WOODMOOR

Water & Sanitation District No. 1

November 22, 2017

RE: The Beach at Woodmoor PUD/Preliminary Plan (PUDSP-17-003) and The Beach at Woodmoor Final Plat (SF-17-015) - REVIEW 2

The Beach at Woodmoor Filing No. 1
Utility System Plan
El Paso County, Colorado

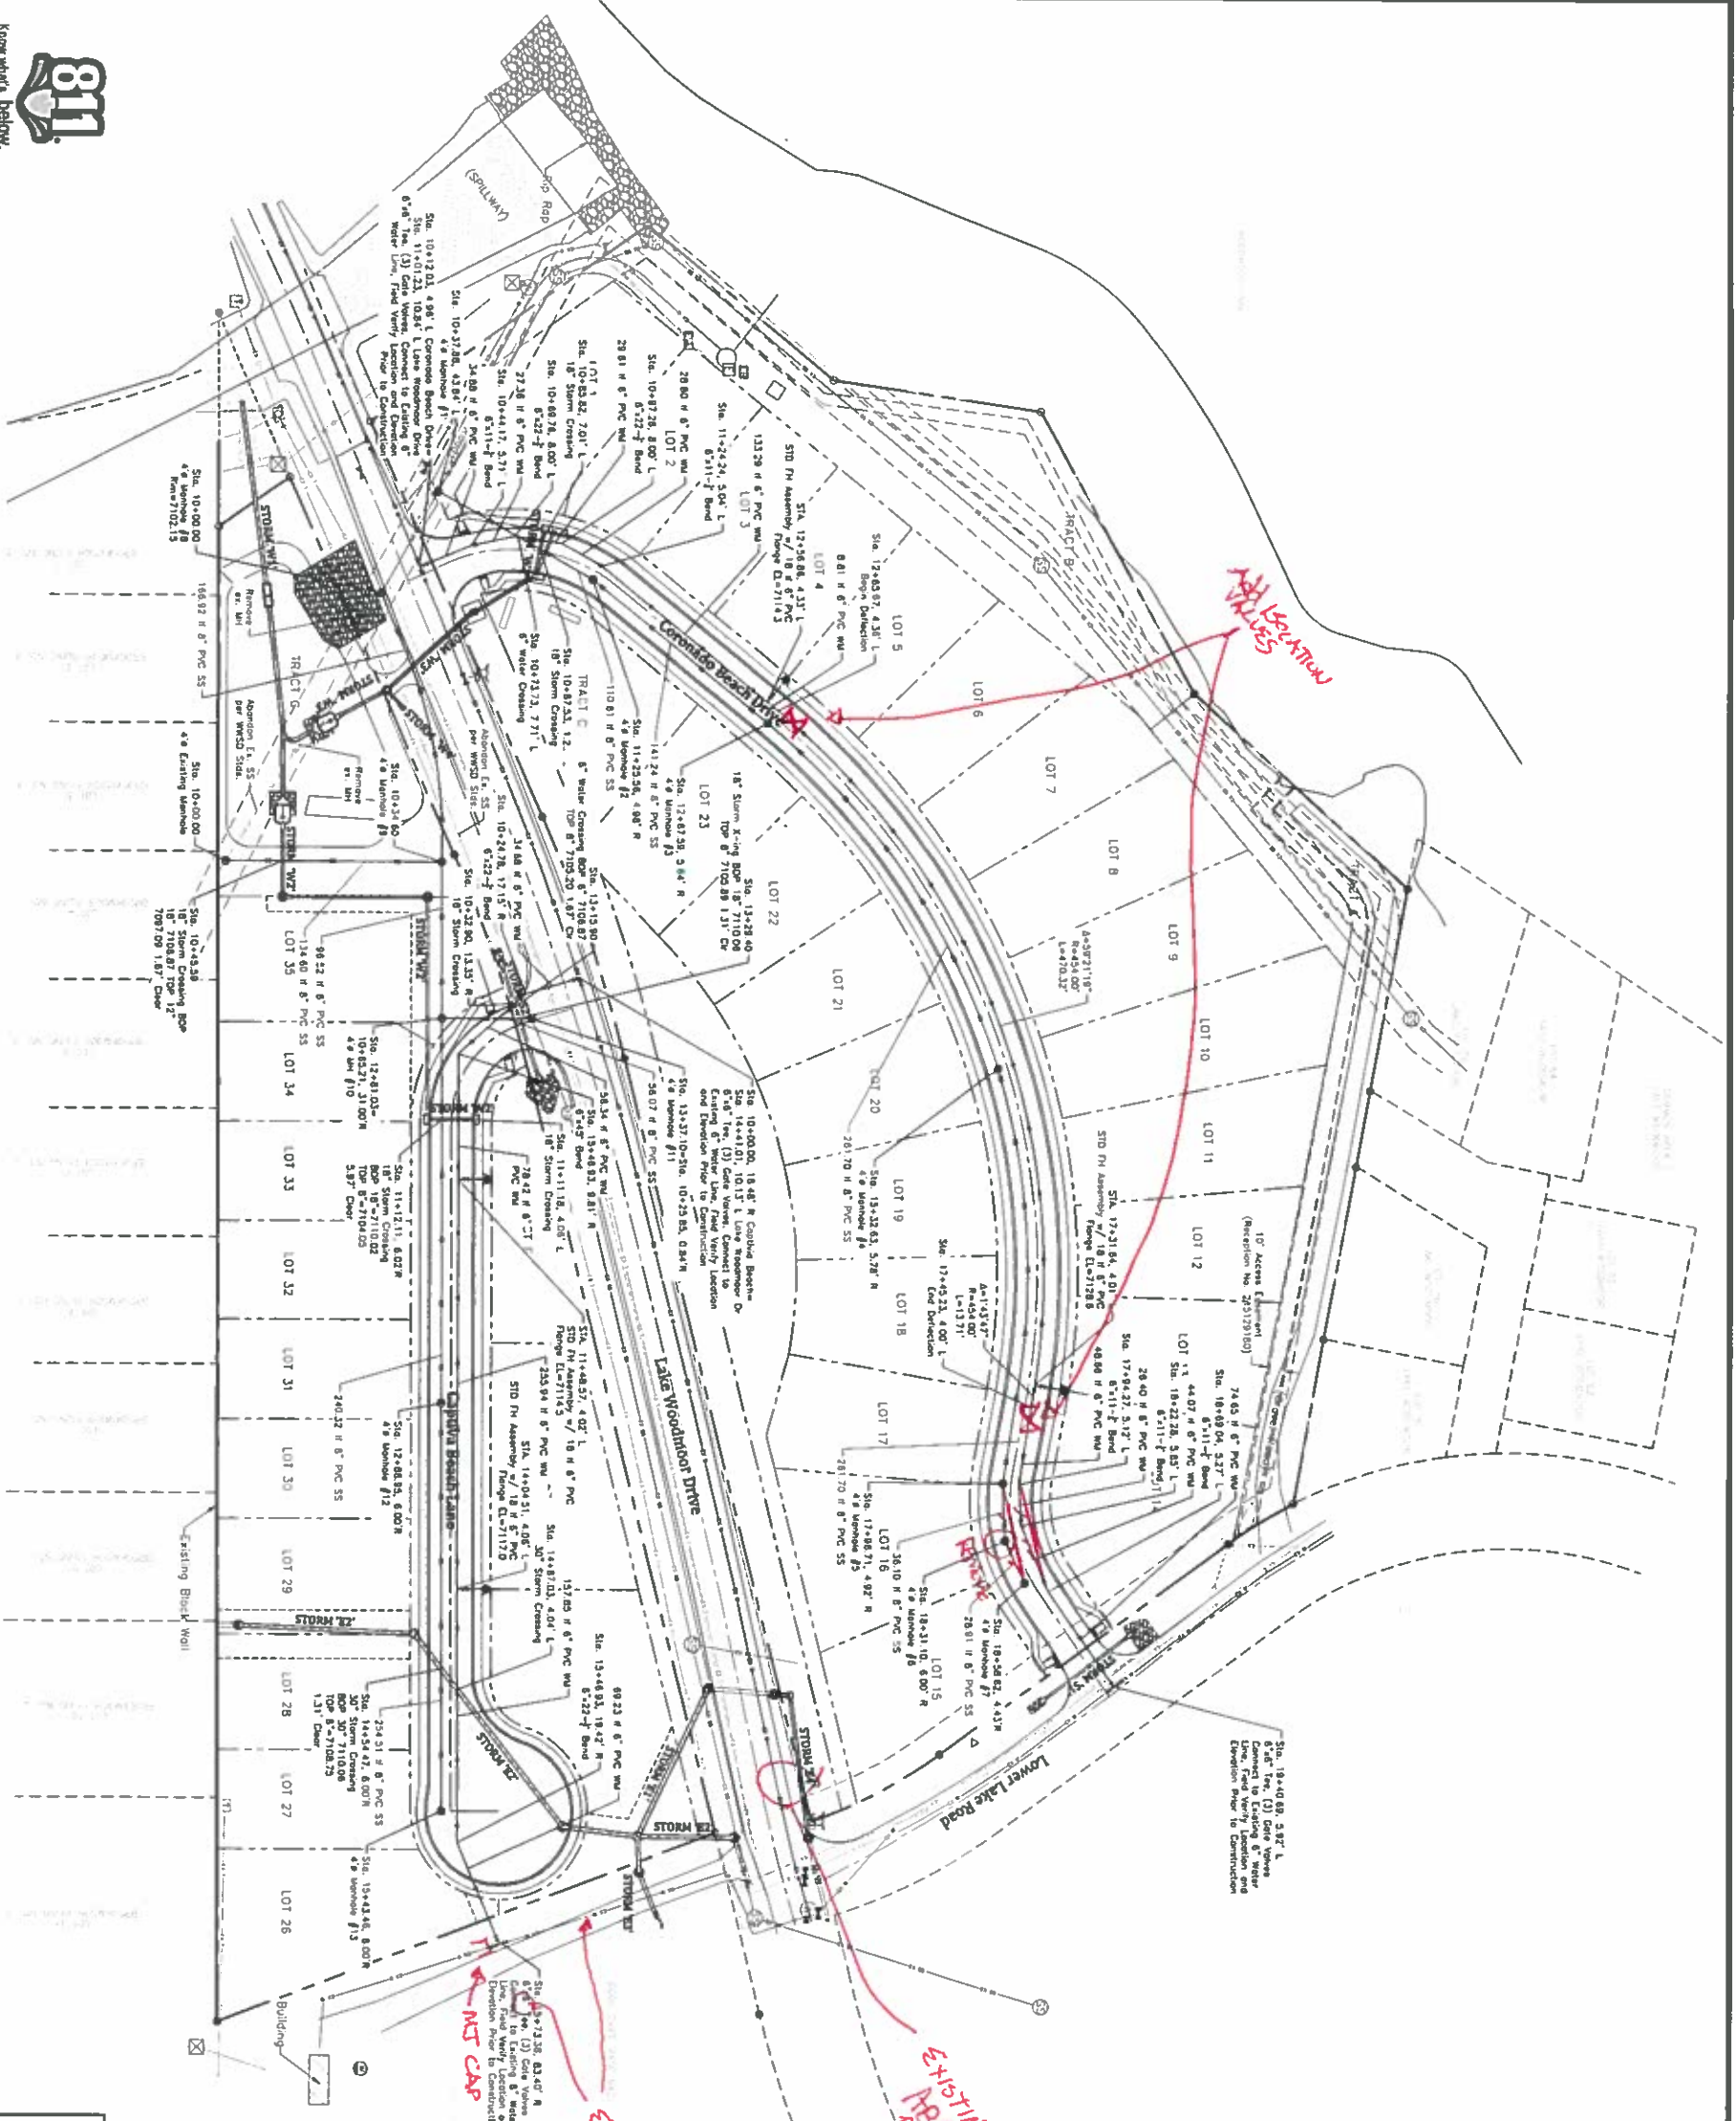
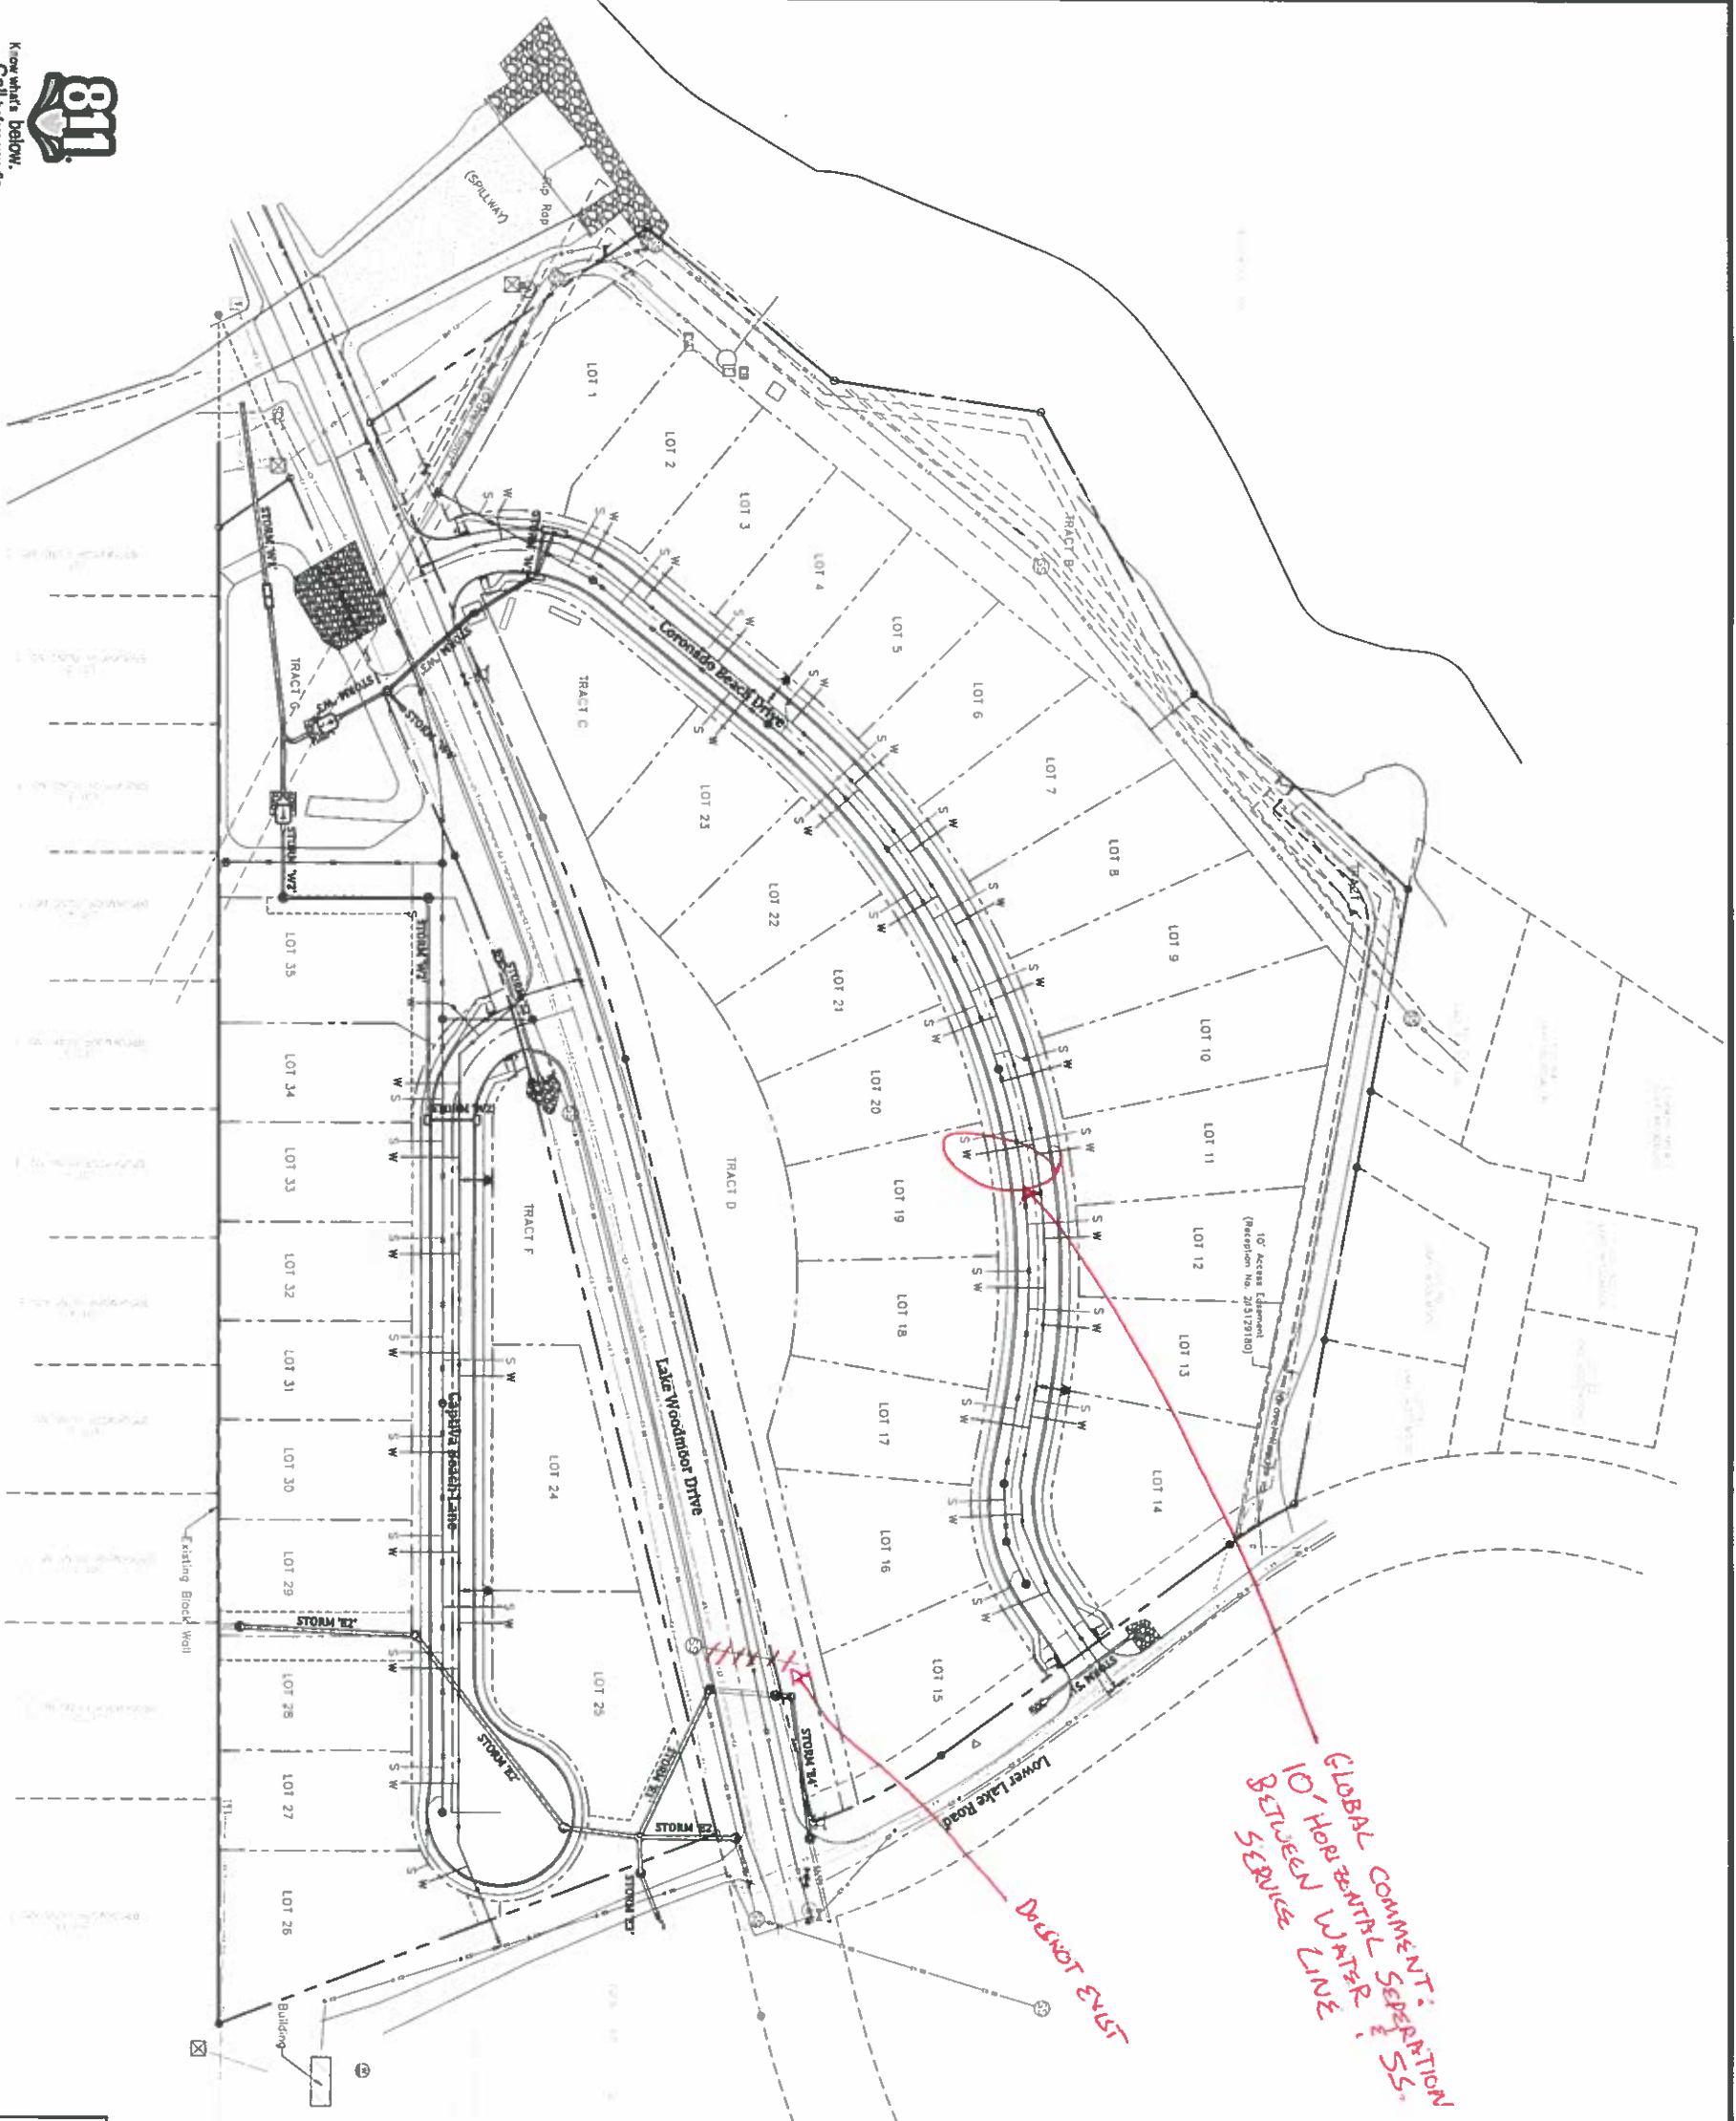
1. As shown on the Utility System Plan, "Storm W1" encroaches into the District's Parcel #14100015 Route storm discharge and storm drainage facilities from the detention facility around WWSD property. Please see attached. It appears this can be accomplished by routing discharges from the detention facility into the R.O.W. of Lake Woodmoor Drive.

2. The District requires two additional water main isolation valves on Coronado Beach Drive. See attached drawing for required locations.
3. Per WWSD System Specifications 3.2.5.a.3, "Manholes will be installed at every change in horizontal or vertical alignment of pipe and for curvilinear alignments; at points of compound and reverse curvature and wherever practical, at the PC and/or PT of curvilinear sewer alignments."
The curvilinear sanitary sewer on Lake Woodmoor Drive requires a manhole at the point-of-curvature. See attached drawing.

4. Remove middle 3 sanitary sewer manholes on Coronado Beach Drive near Lower Lake Road and straighten run of pipe on sanitary sewer line between two remaining manholes. Straighten curved water main such that it runs near or under curb and gutter to maintain 10' separation between water and sewer mains.

5. Ensure minimum 10' horizontal separation between water and sanitary sewer service lines. See Lot 19 for example of needed correction.
